WEST SUSSEX COUNTY COUNCIL CONSULTATION

TO:	Arun District Council FAO: S Davis
FROM:	WSCC - Highways Authority
DATE:	4 July 2019
LOCATION:	Chandlers Garage Bmw House Water Lane Littlehampton BN16 4EH
SUBJECT:	A/45/19/PL Demolition of existing buildings (car show room, workshops and Phares Courtledge) and erection of 19 dwellings, a convenience store, a community building, public toilets and associated car parking and landscaping - This application affects the character and appearance of the Angmering Conservation Area. More information.
DATE OF SITE VISIT:	
RECOMMENDATION:	No Objection
S106 CONTRIBUTION TOTAL:	£ 97,006

Scale	1:250	Drawn By	SMO	Checked By	ALB	Approved By	PMR
Date	March 2019	Drawing No	2018-4619-001	Rev.			C

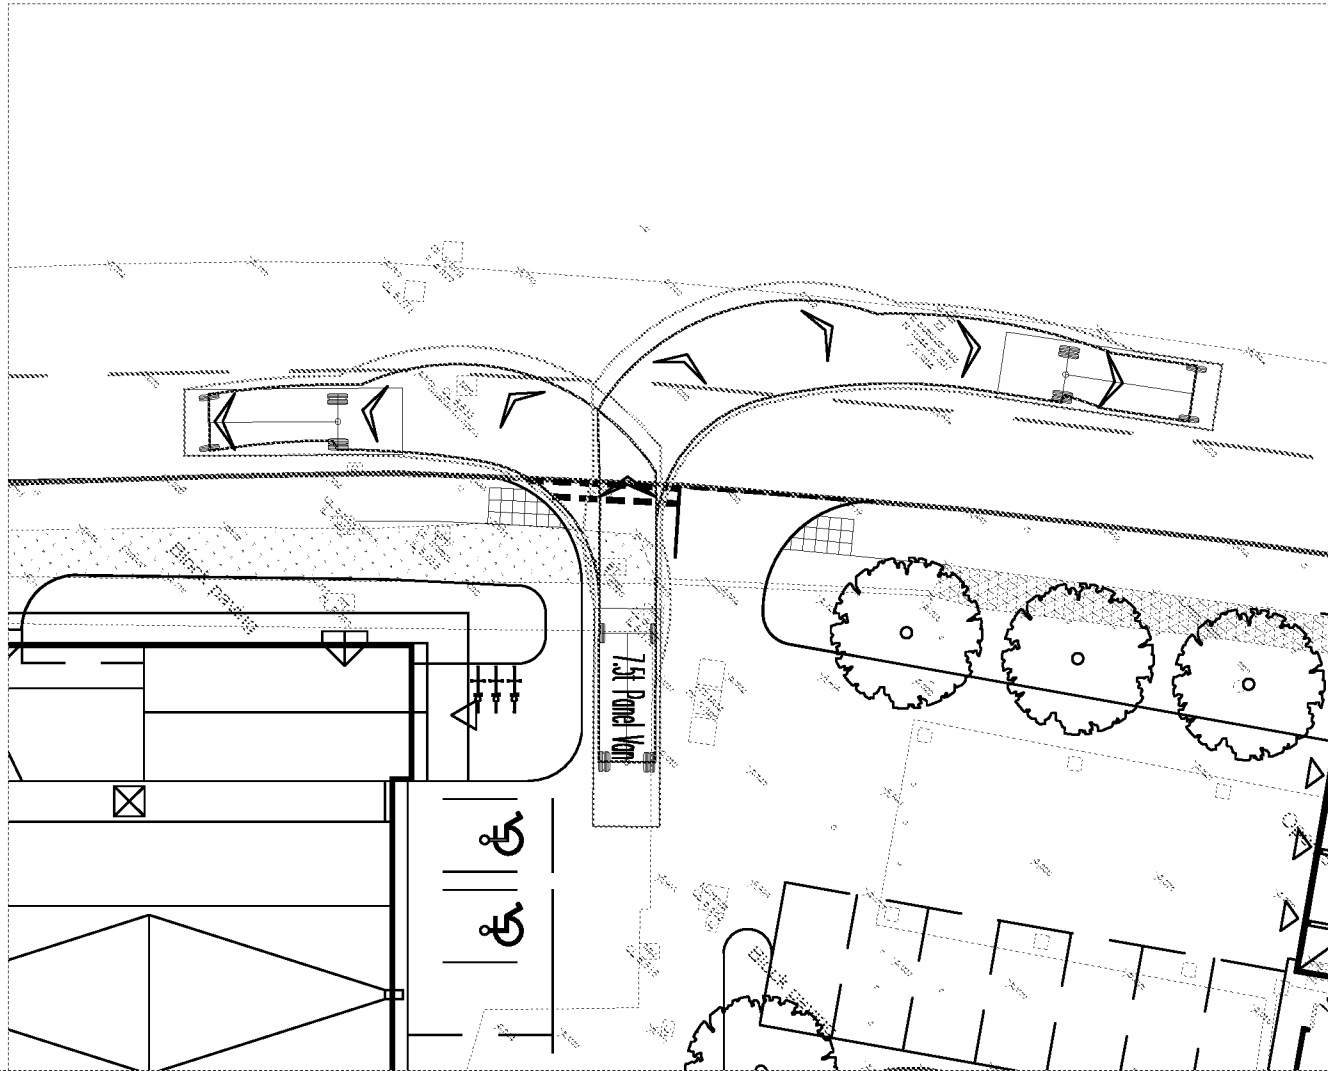
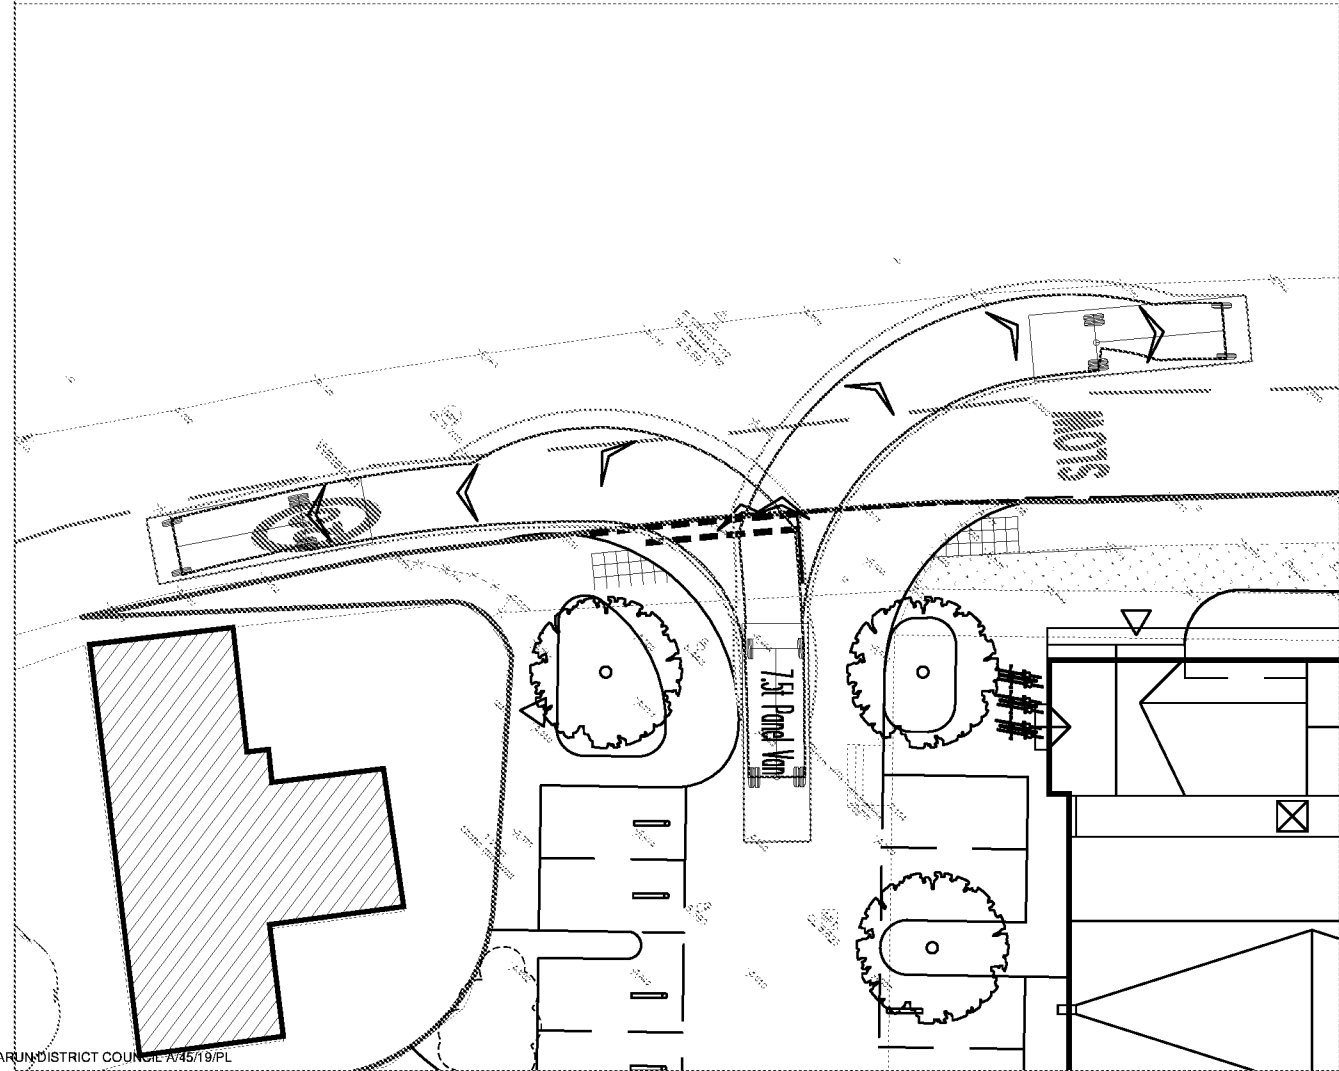
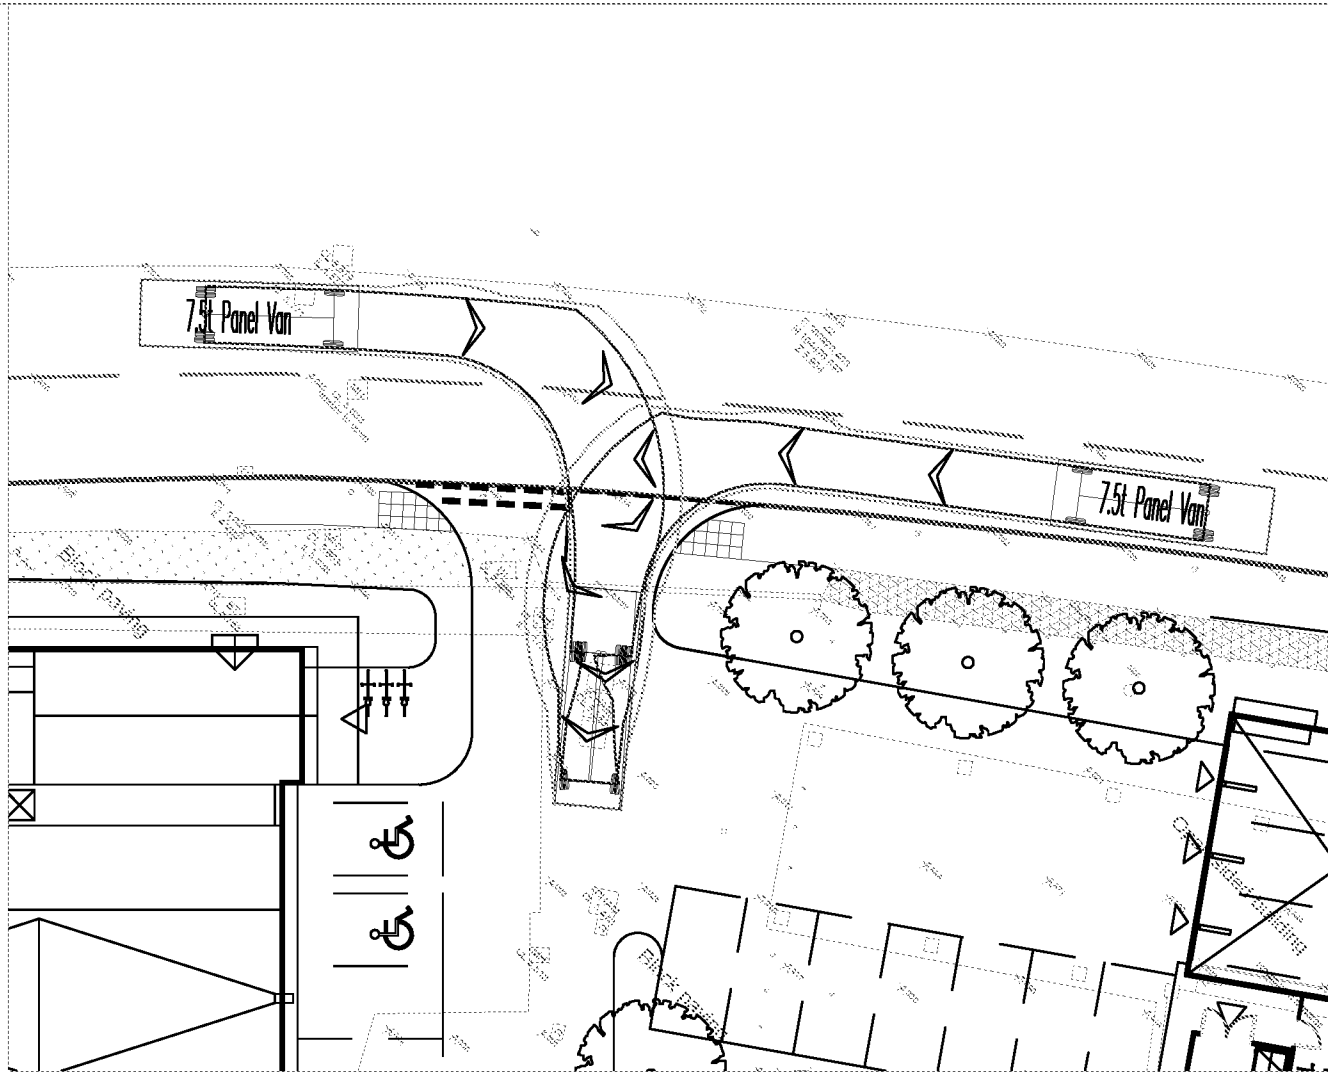
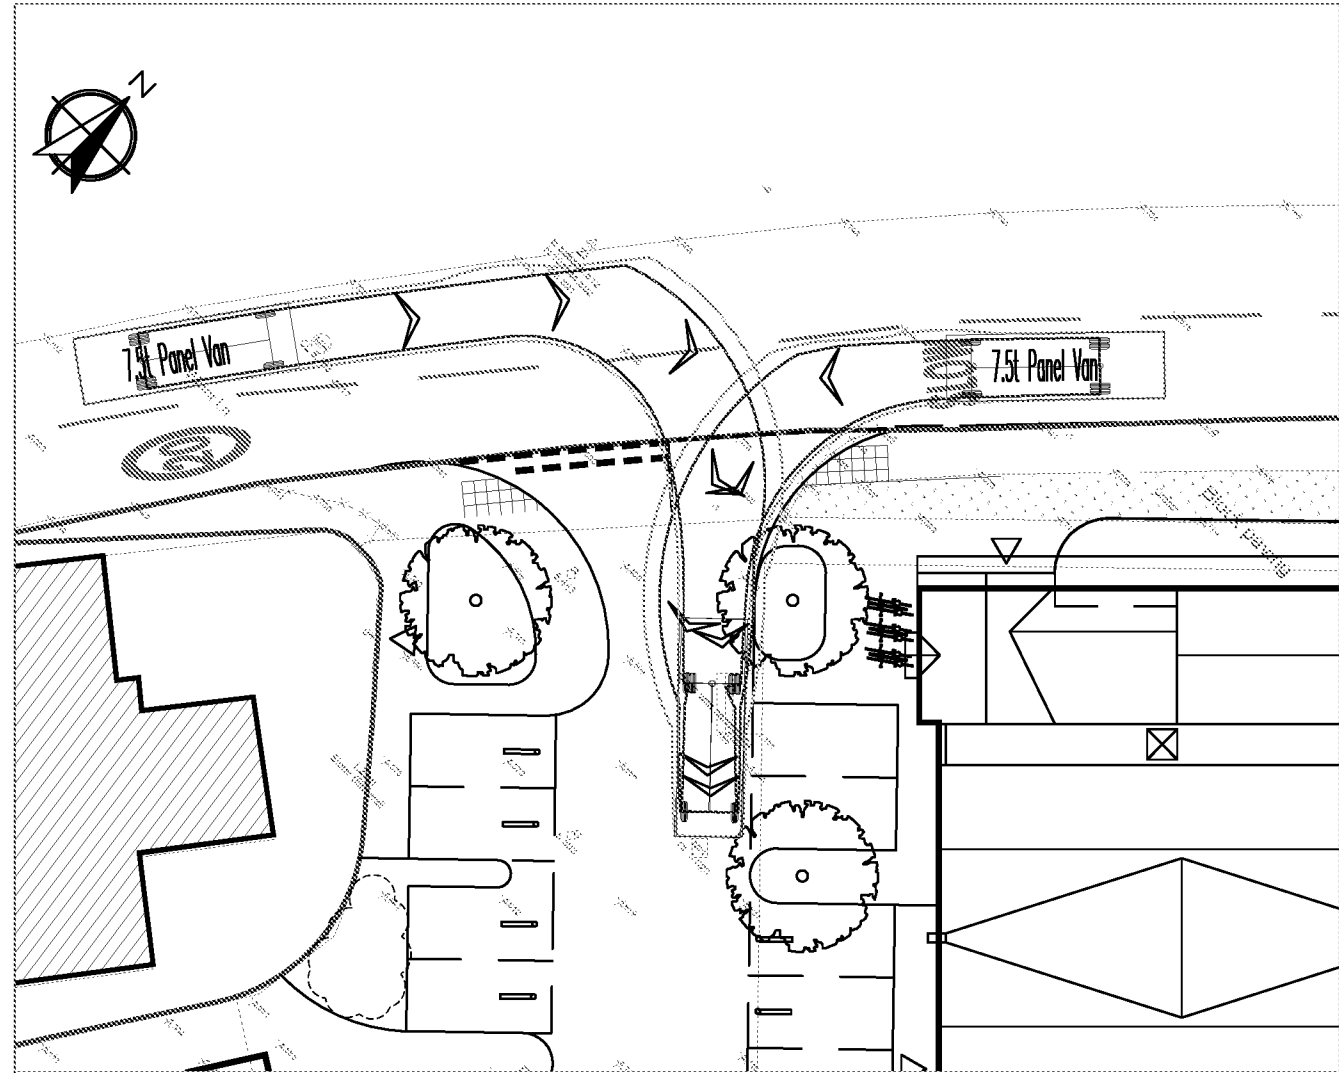
A speed survey has been undertaken, to ascertain the 85th percentile road speeds. Adjusted for wet weather the speeds are:

- 26.0 mph-Northbound
- 26.6 mph- Southbound

The visibility splays therefore would be anticipated to be 35.1metres southbound and 36.2 metres northbound. This splay is achievable at the eastern access in both directions. In the western access, the southern visibility splay is obscured slightly by the neighbouring boundary wall- not within control of the applicant. The visibility splay in

this direction has been shown a 36.2m to the centre line. The LHA has considered this reduced visibility splay and considers the precedent set by this existing access point. Good forward visibility along water lane presents opportunity for a vehicle waiting at the access to be seen, and the presence of parked vehicles along the northern carriageway encourages vehicles to proceed cautiously.

Section 10.6.1 of Manual for Streets 2 (MfS2) states the absence of wide visibility splays at minor accesses will encourage drivers to emerge more cautiously, similarly to how vehicles emerge onto the highway when visibility along the carriageway is restricted. Section 10.6.2 also states that the frequency of vehicular movements should also be taken into account, this is discussed in more detail within the Capacity section of this report however; capacity has been assessed and found to not raise any severe concern.

No part of the development shall be first occupied until visibility splays of 2.4 metres by 36.2 metres have been provided at the proposed site vehicular accesses onto Water Lane in accordance with the approved planning drawings. Once provided the splays shall thereafter be maintained and kept free of all obstructions over a height of 0.6 metre above adjoining carriageway level or as otherwise agreed.
